An
Bord
Pleanála

Board Direction
BD-018948-25
ABP-318683-23

The Board decided to grant permission under section 37G of the Planning and Development Act 2000, as amended, generally in accordance with the Inspector's recommendation, for the following reasons and considerations, and subject to the following conditions.

CLIENT:	STARRUS ECO HOLDINGS LIMITED (SEHL)		
PROJECT:	BALLYMOUNT ROAD UPPER, DUBLIN 24		
TITLE:	PROPOSED ELEVATIONS, ACOUSTIC BARRIER, WEIGHBRIDGE & SUBSTATION		
DRAWN:	CHECKED:	APPROVED:	JOB NO:
CB	CB	OD	221244
DATE:	SCALE:	DRAWING NO:	REV:
01/12/2023	1:200	221244-ORS-Z1-ZZ-DR-AR-206	P06

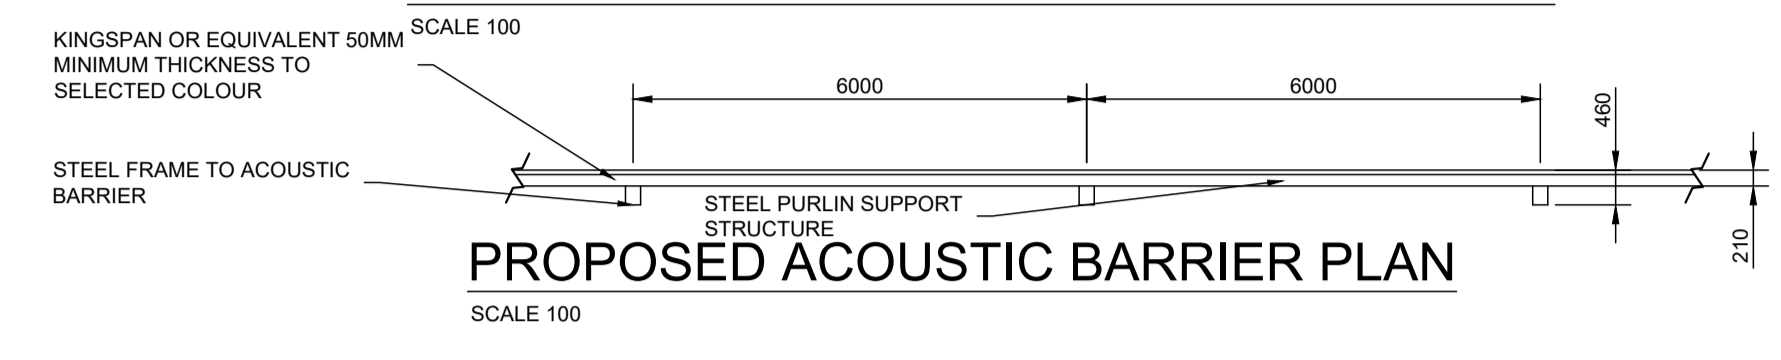
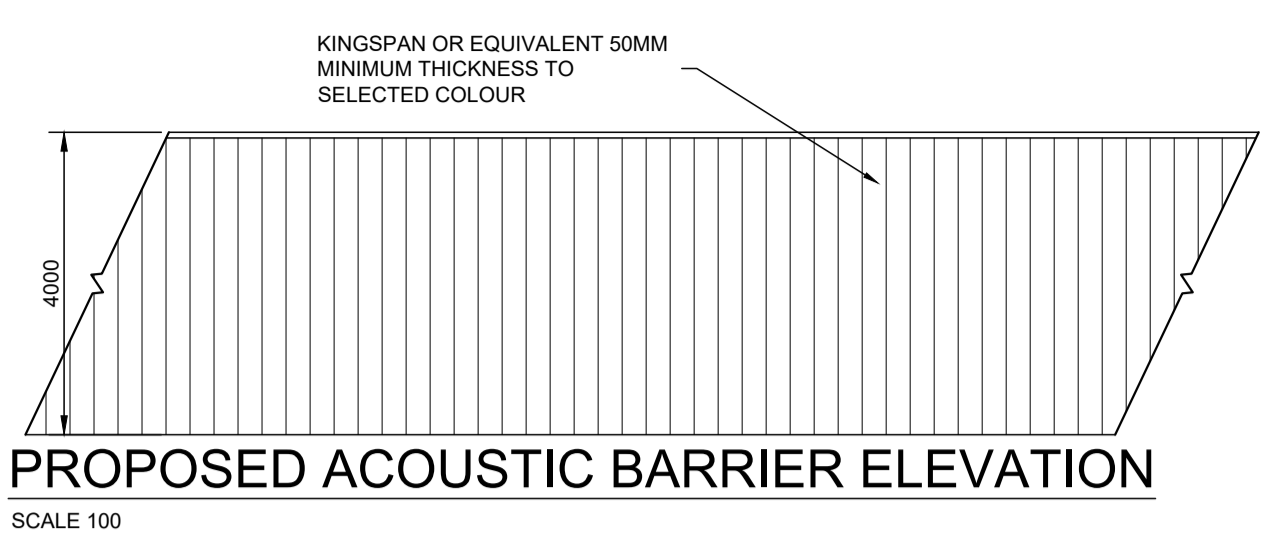
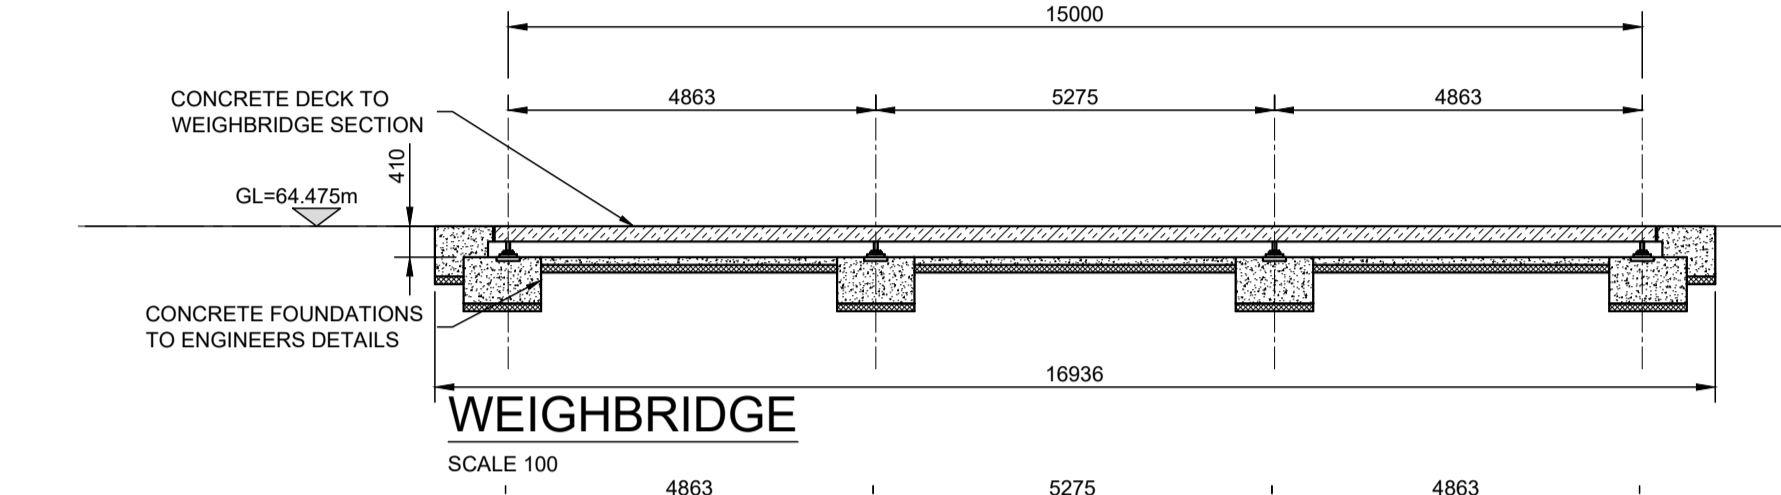
4. Prior to operation of the facility hereby permitted, a 4-metre-high solid noise barrier shall be erected along the south-eastern boundary of the site in accordance with drawing number 221244-ORS-Z0-00-DR-AR-206.
